Settlement City Shopping Centre Port Macquarie

Environmental Assessment Proposed Stage 1 Preferred Project Report

December 2009

DRAWING NO: 101
ISSUE: December 2009 (J)
CLIENT: ING Real Estate
SI JOB NO: SS09-1850

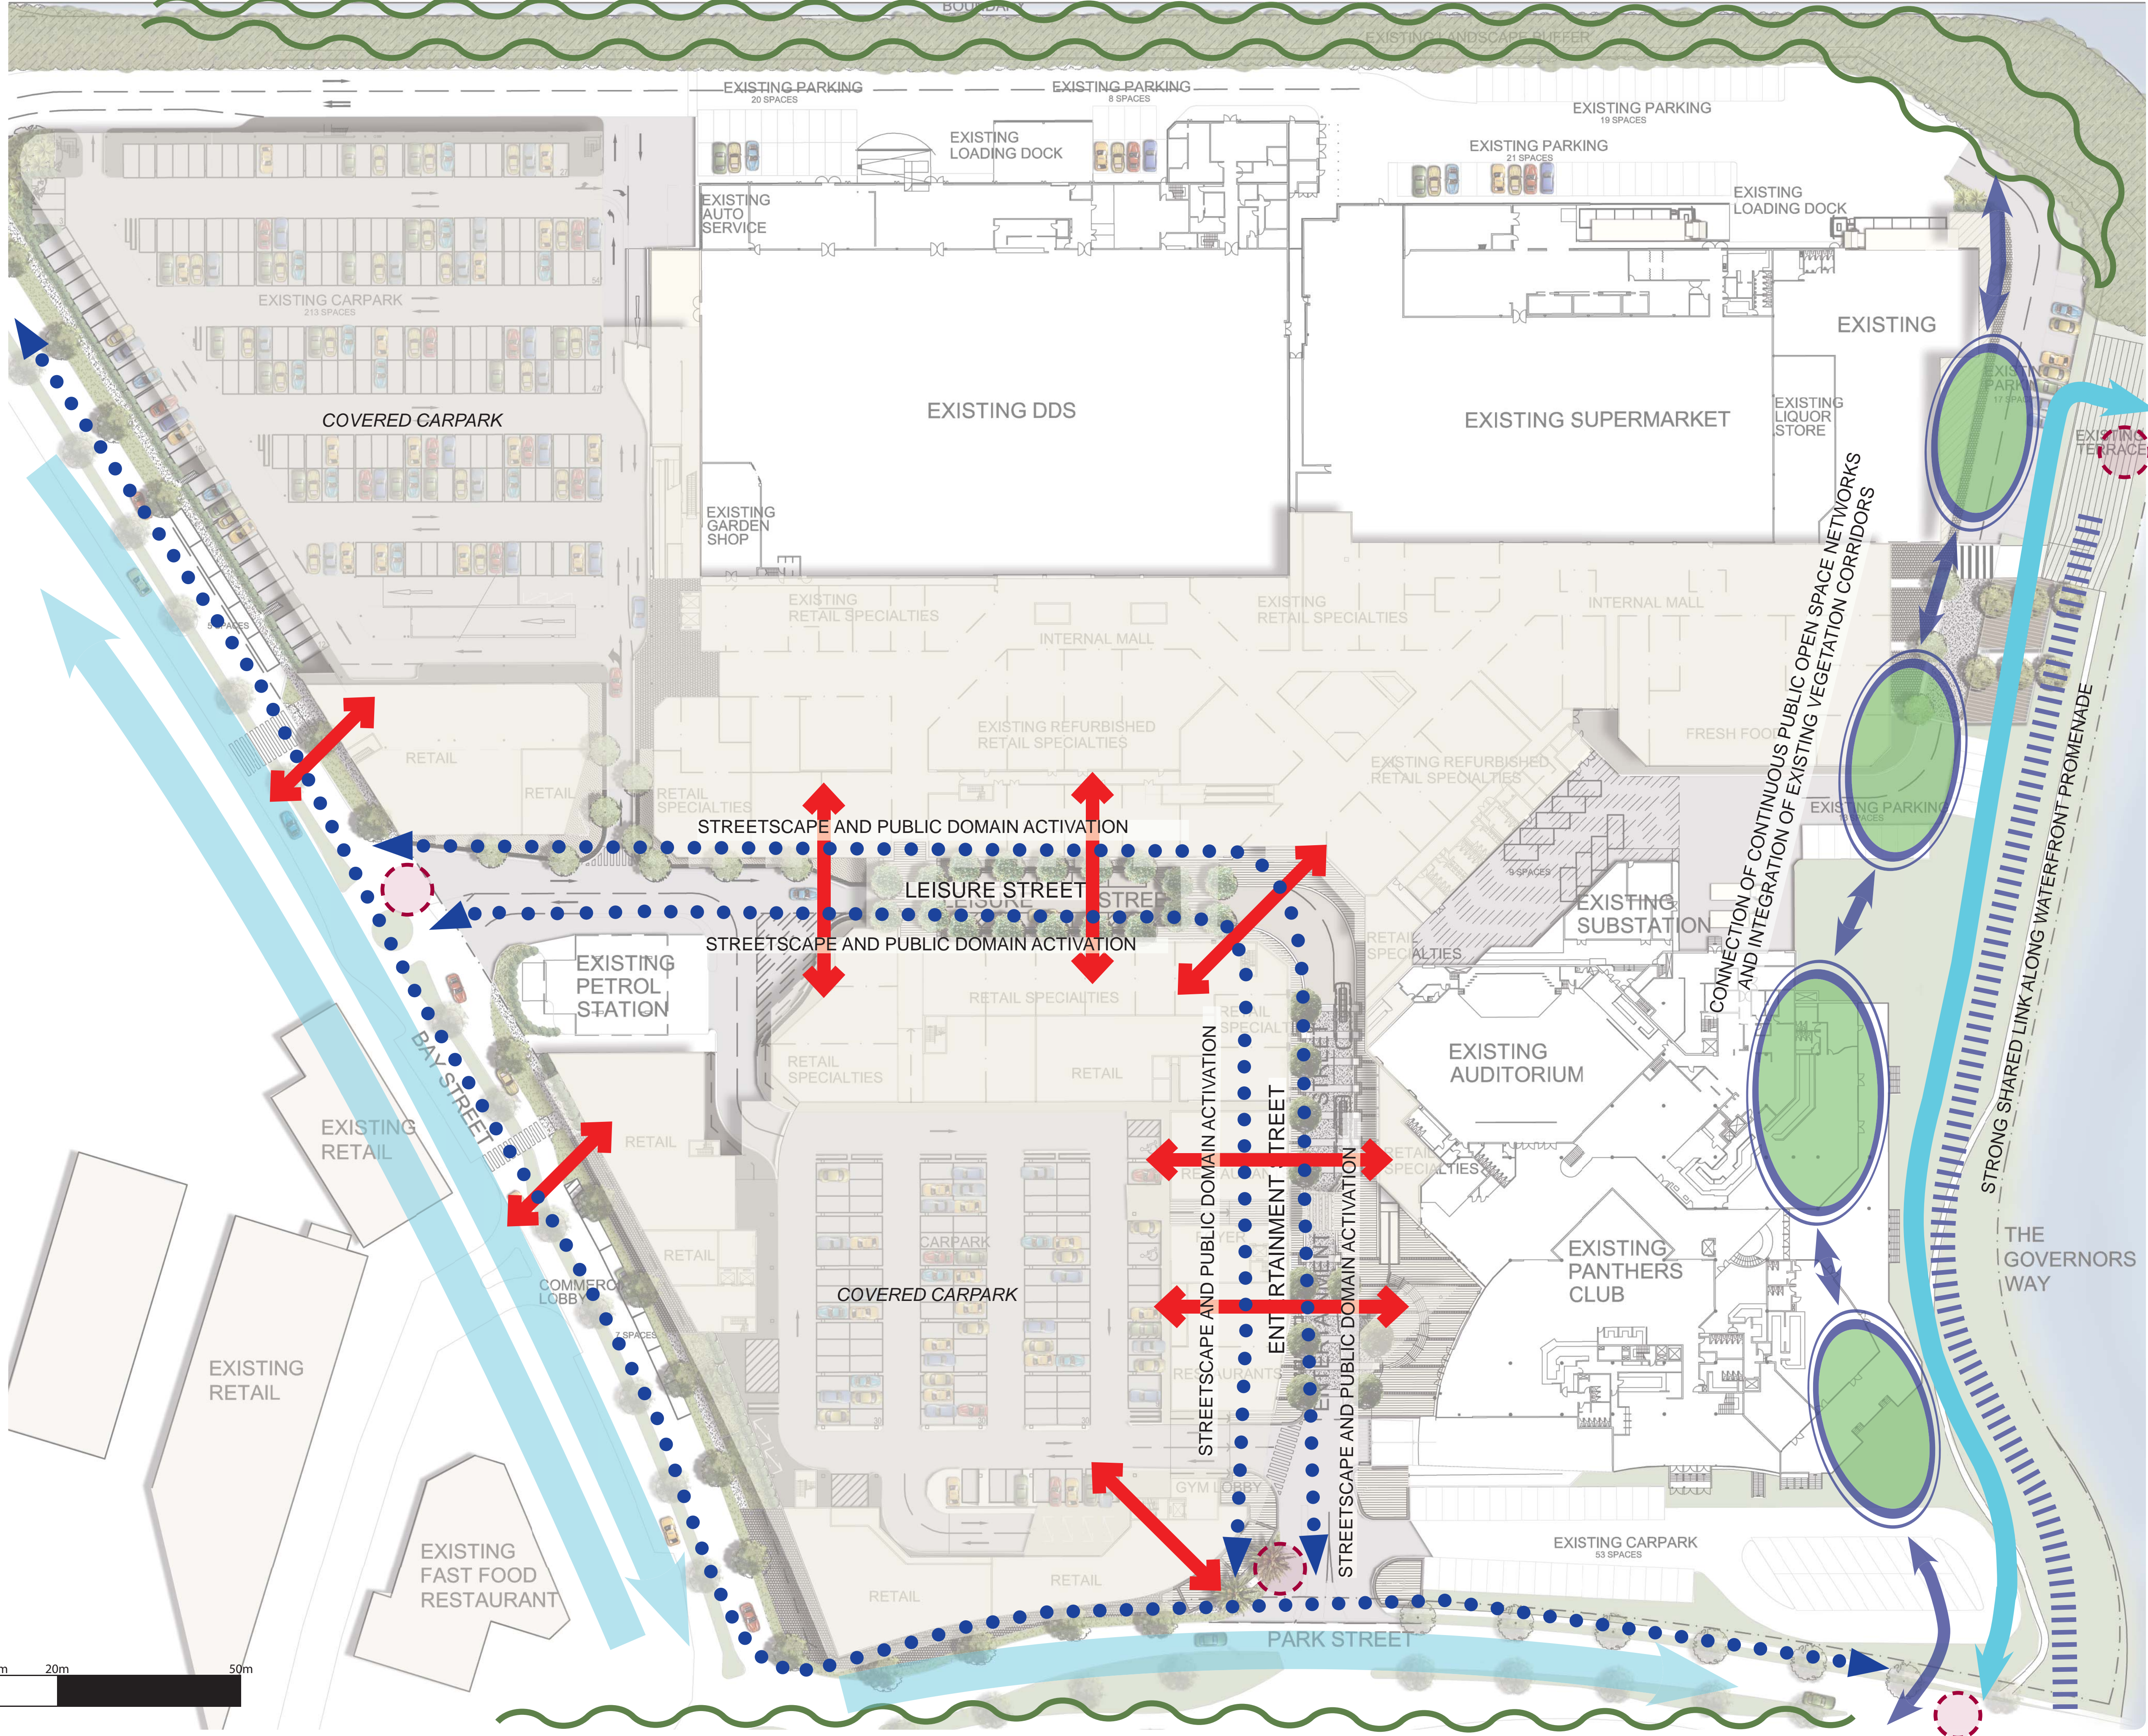
- 1.3 Improved active use/s along the eastern frontage to Bay Street as part of the proposed alterations to the existing multi-level carpark in the south-western corner of the site is required.

New retail frontage is proposed to the corner of Bay Street and Leisure Street, landscaping treatments to the existing carpark structure will assist in activating and revitalising this existing elevation

Reference: Landscape Masterplan Stage 1 Dwg 101B
